# CITY OF ALBUQUERQUE

**RE:** 18<sup>th</sup> & Lomas Townhouse  
Grading and drainage Plan  
Engineer's Stamp Date 11-18-16 (File: J13D203)

Based upon the information provided in your submittal received 11-18-16, the above referenced submittal cannot be approved for Building Permit, until the following comments are addressed:

Drainage & Grading Plan

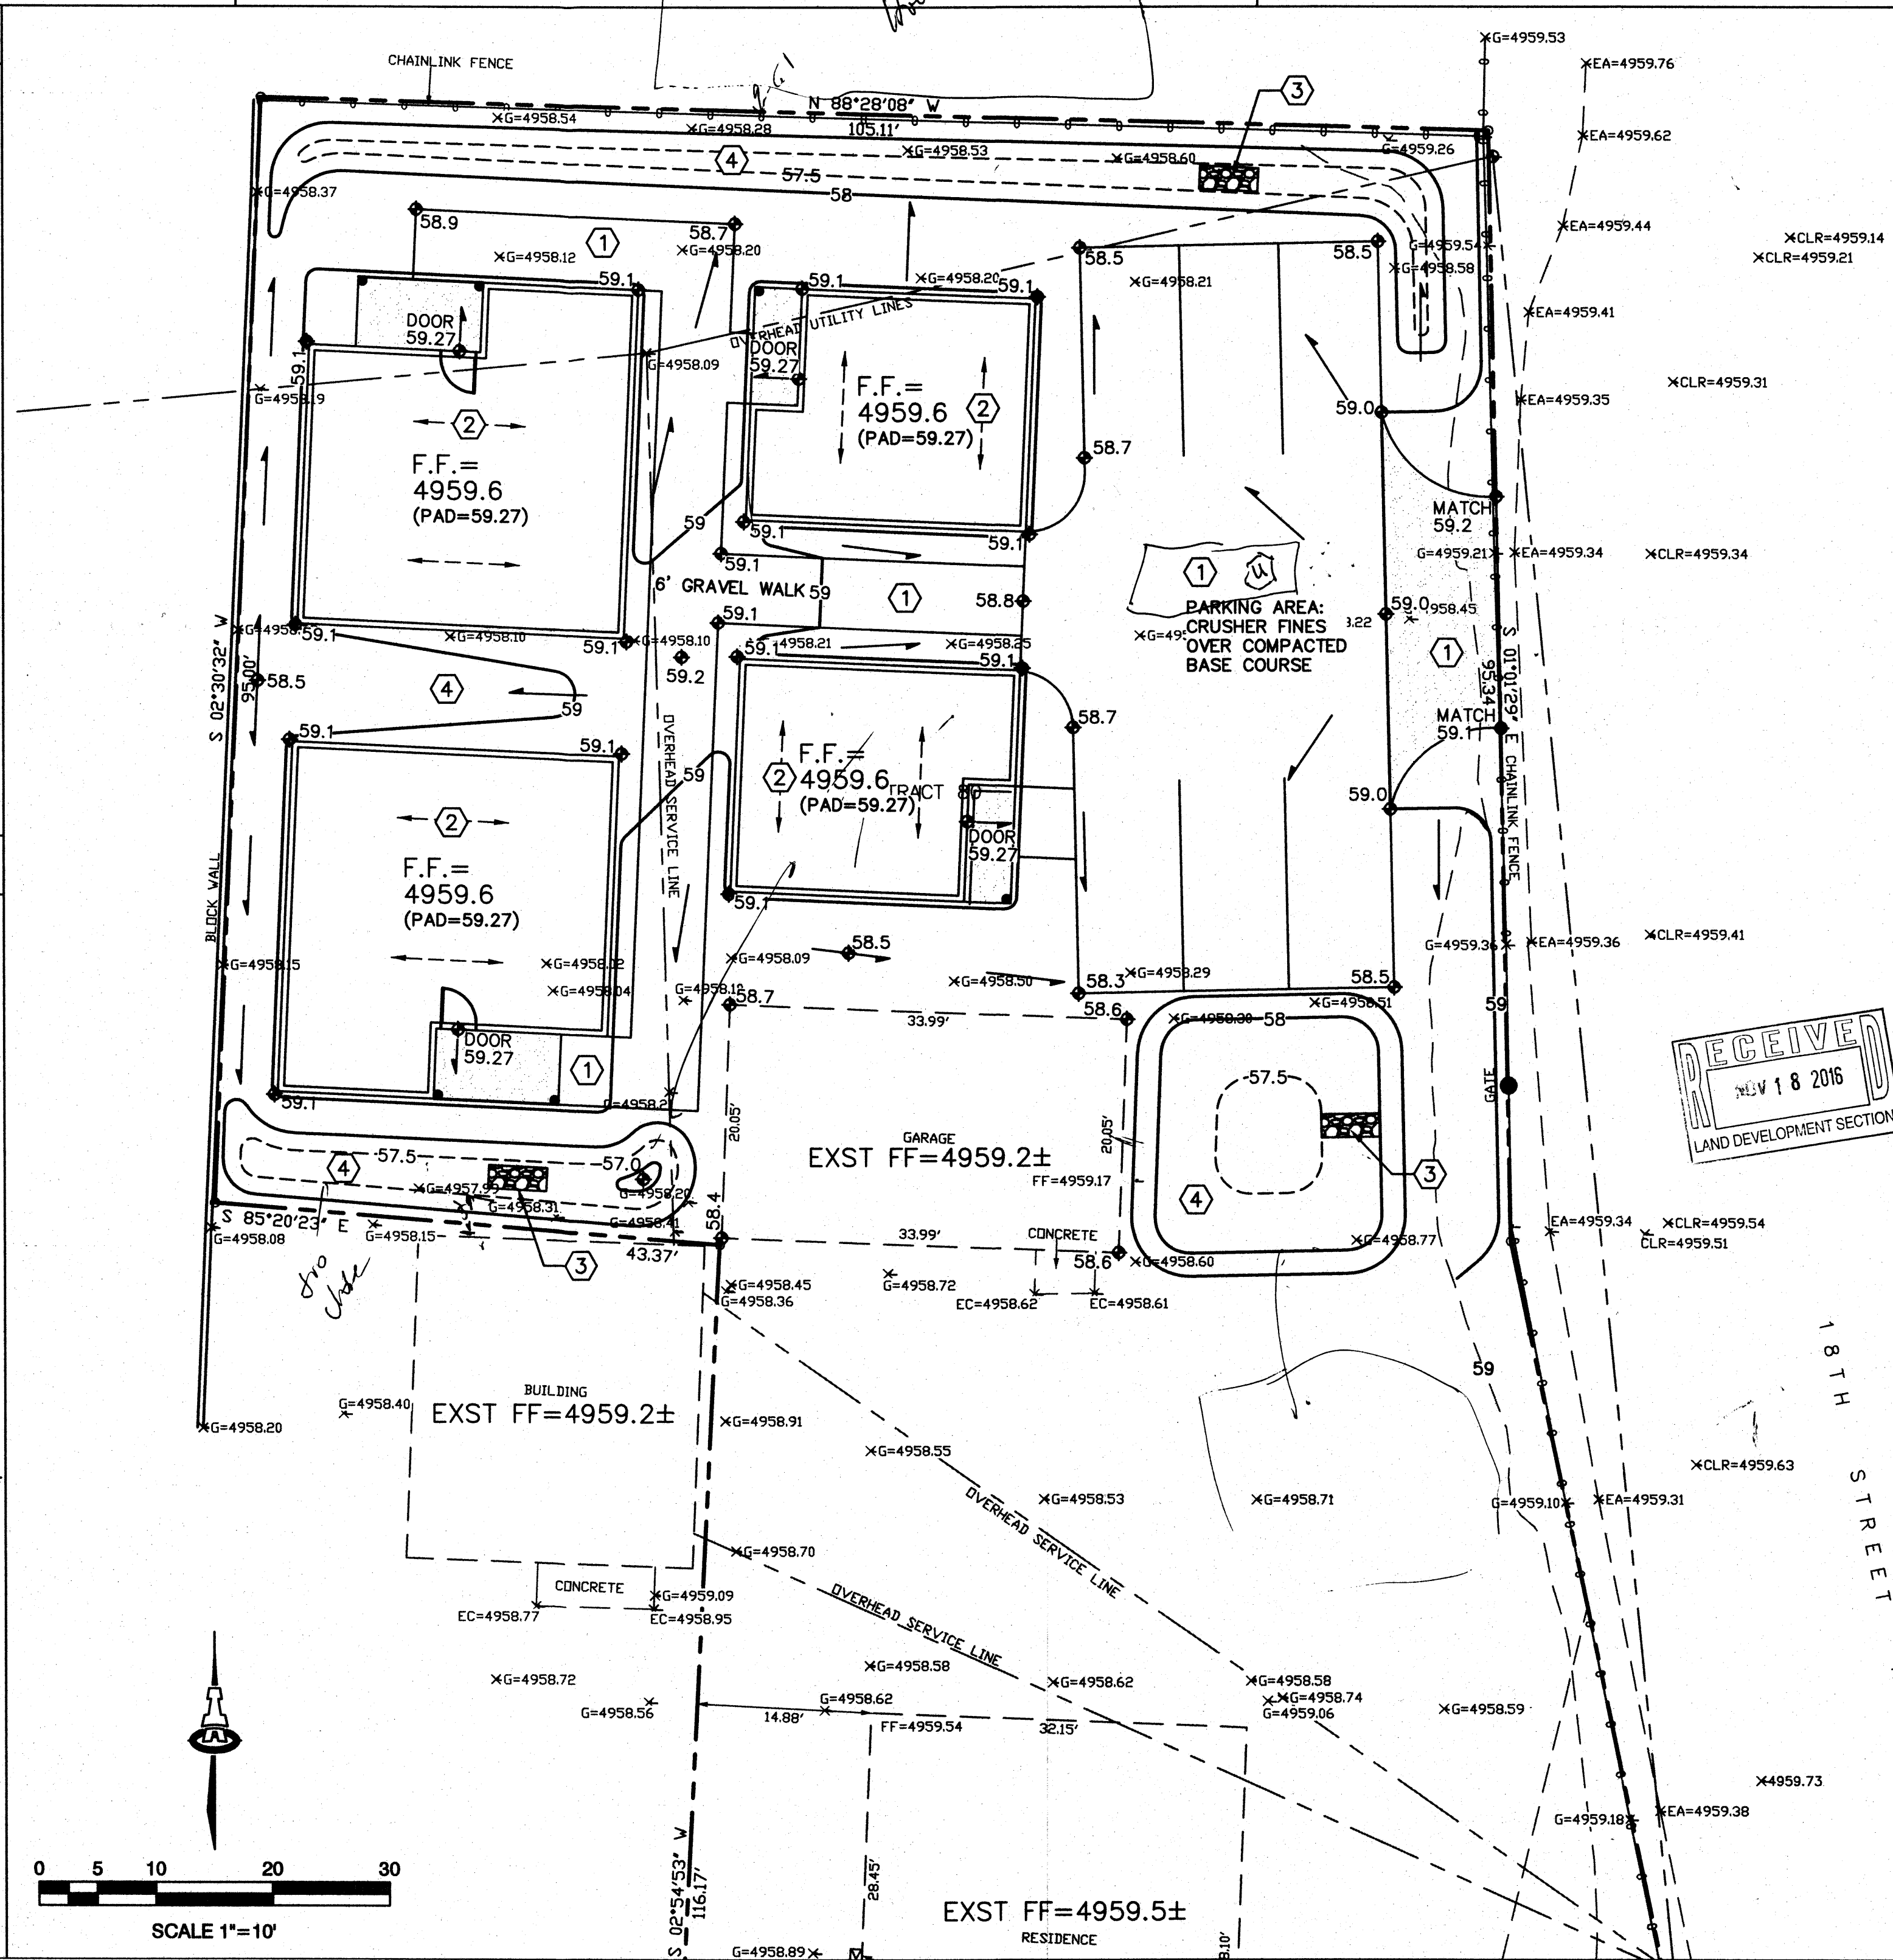
1. Are the ponds in the south west and in the north too close to existing structure?  
Will they effect the foundation?
2. An infiltration system design should have the width or length dimensions, in plan view, greater than the depth dimension otherwise it is considered an injection well and a permit from the New Mexico Environment Department is required.
3. The infiltration system design should include a filter material to prevent fine material from entering the system.
